Planning Application Ref: M/39/17/HH

Location: Middleton House, Yapton Road, Middleton on Sea

Description of works: Extend house to the rear and construct a detached garage at the front of the property.

Existing Tree Survey

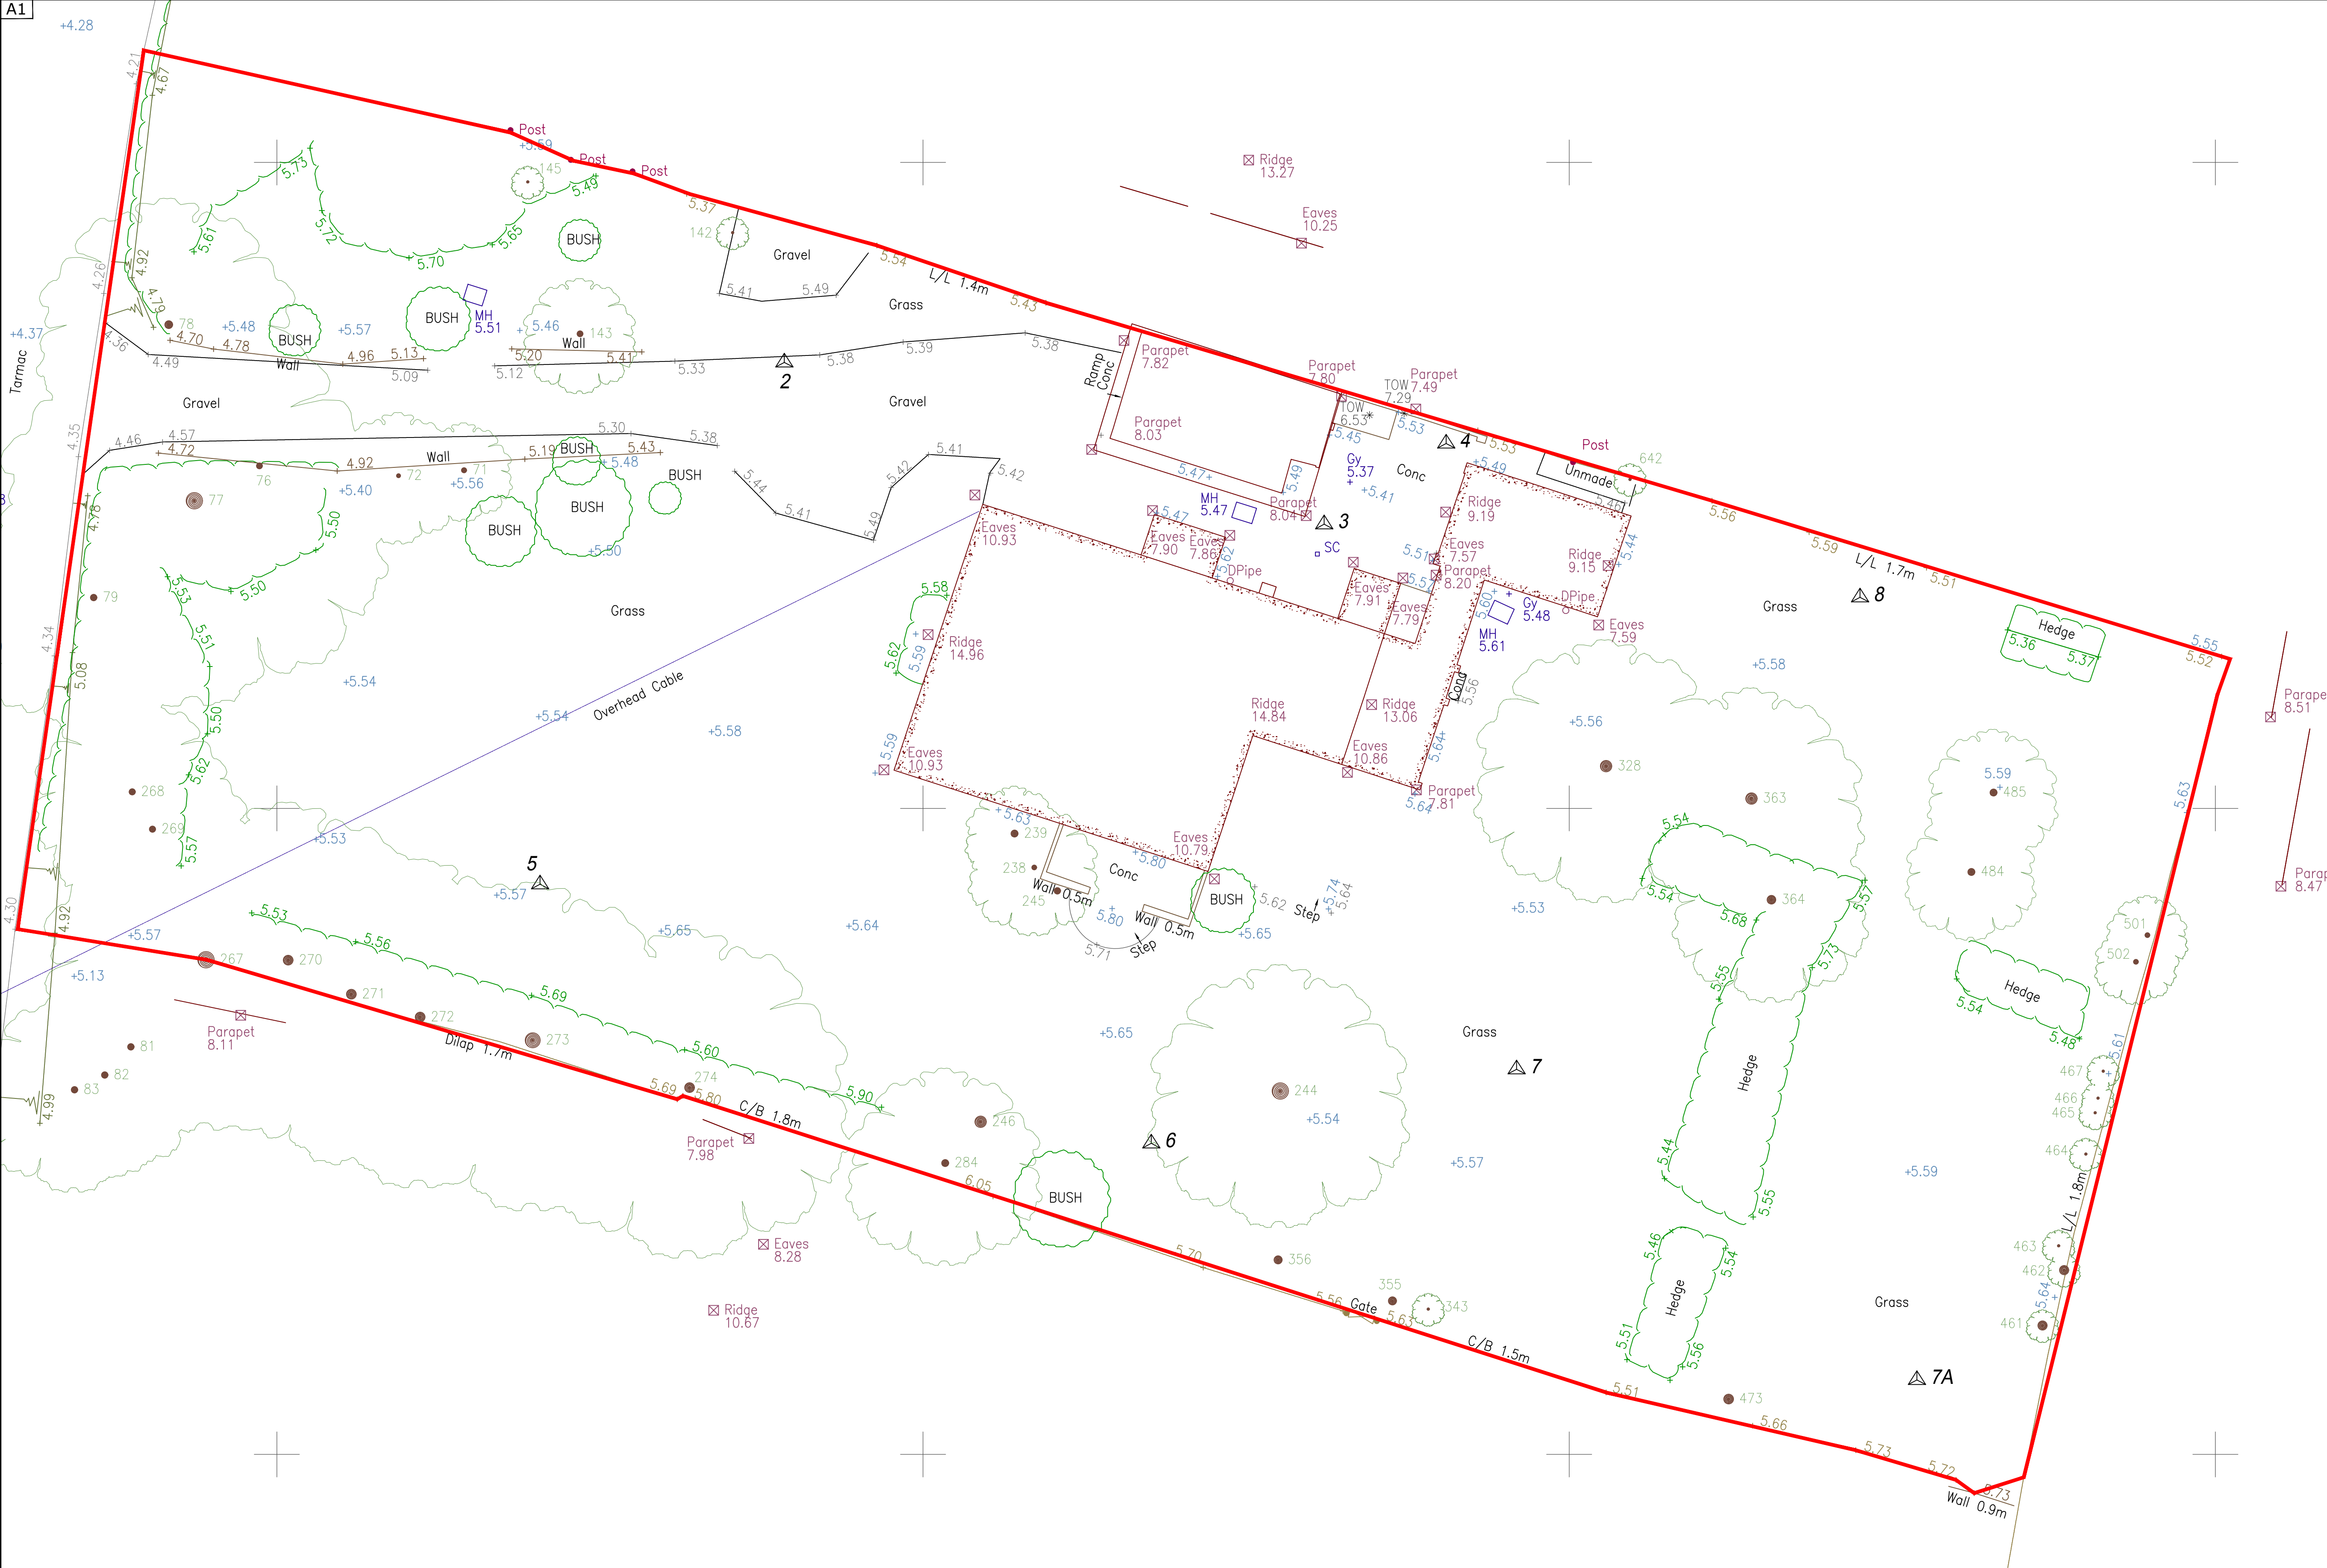
- There are two **Apple** trees close to the rear of this new extension – the closest is of very poor quality and should really be removed prior to any works starting on site. The furthest tree is dead.
- There is a **Walnut** to the southeast side of the house – it has rootplate lifted in the past and attempts have been made to prop it up – **IF** the intention is to retain this tree then it should be protected during the build process.
- At the front of the property along the southern boundary line there is a line of Leyland Cypress of poor quality that will be quite close to the position of the new garage – they will not be affected by these proposals.

- The two **Apple** trees should be removed.
- The **Walnut** can be protected by erecting HERAS panels in rubber blocks to encompass its crown spread.
- The **Leylandii** require no protection measures to be applied.
